Re: SB/2013/2202/FP

Erection of side, rear single storey and side
and rear first floor extensions at
17 Kingsmead, Cuffley EN6,

Dwg. No. PA04

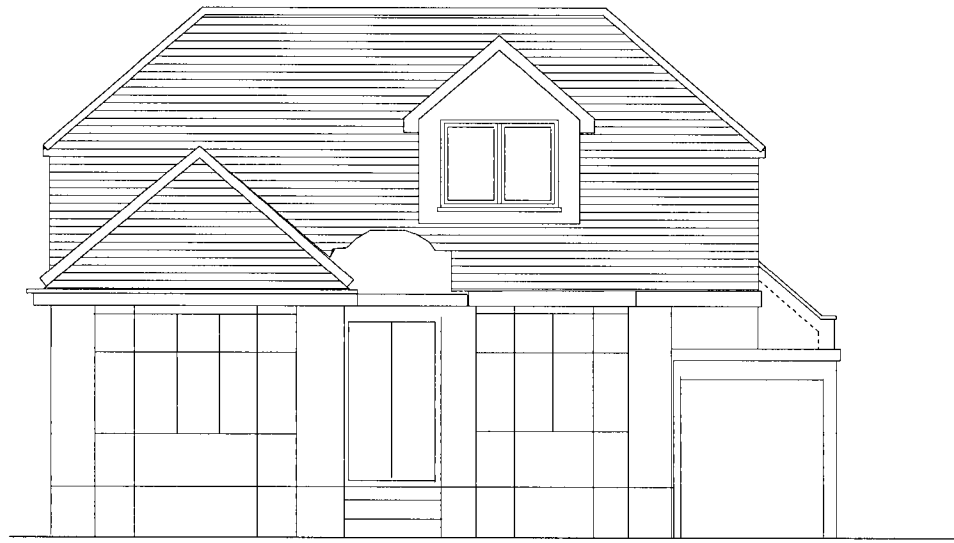
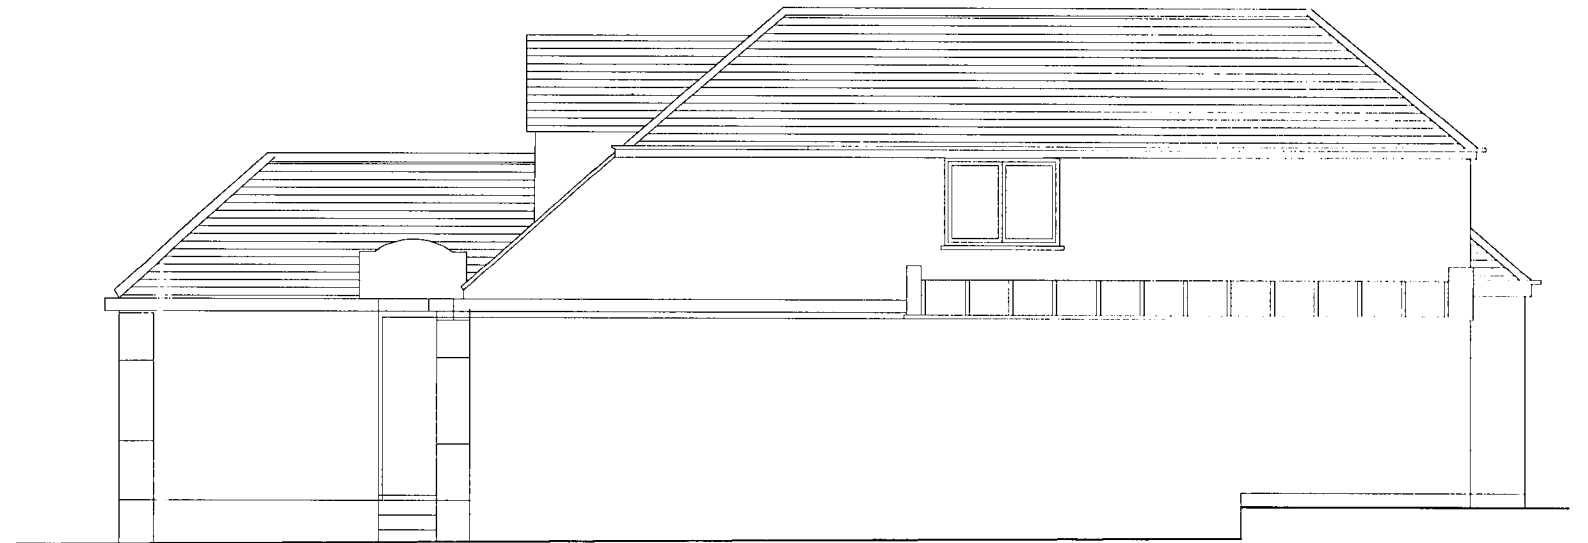
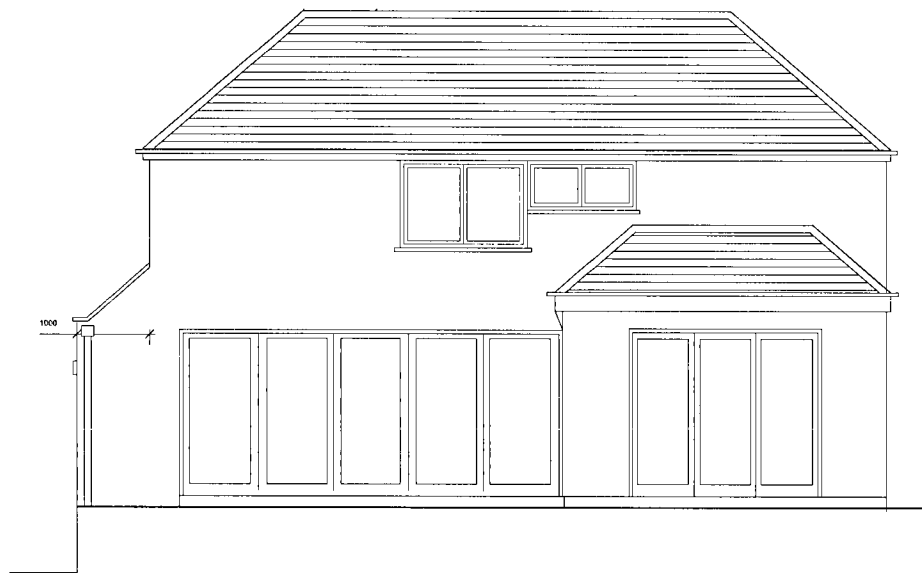
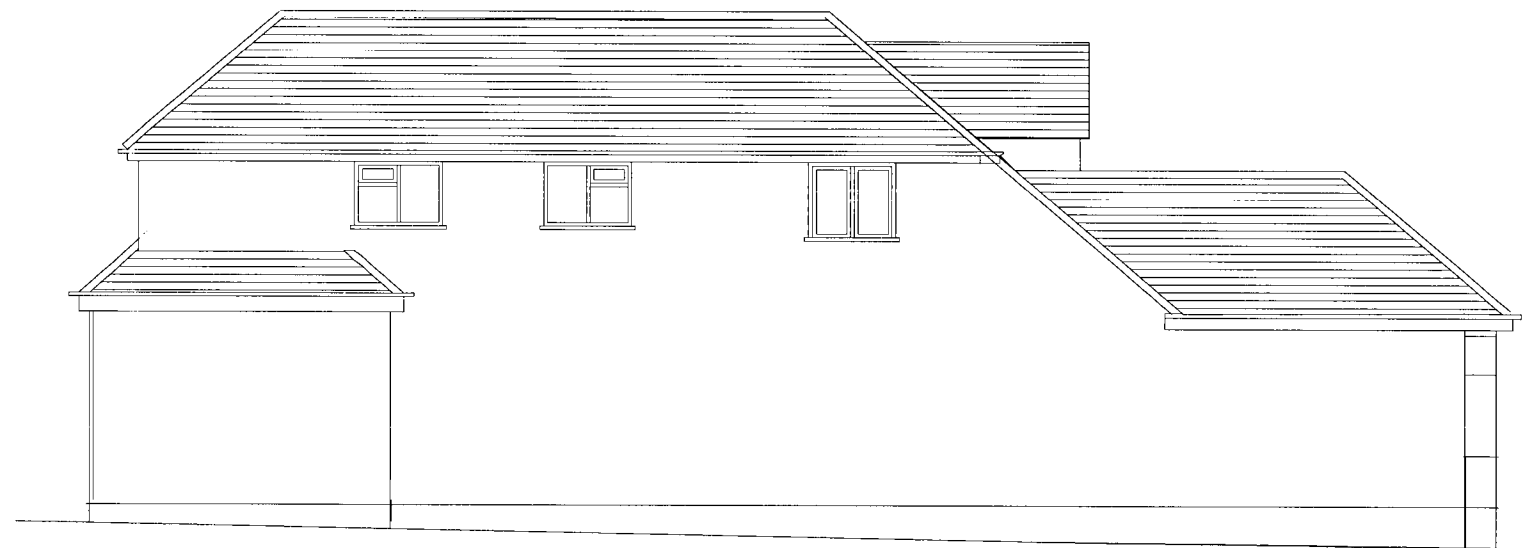
- I feel that an extension(s) of this size is out of character in a small road of existing bungalows

- by basically marking this bungalow into a 2 storey house, we feel that it is out of keeping with the rest of the cul-de-sac

- furthermore, we feel it will be overbearing to neighbours who back onto the side of the garage at No 17.

- the 2 storey extension will also restrict view of countryside beyond.
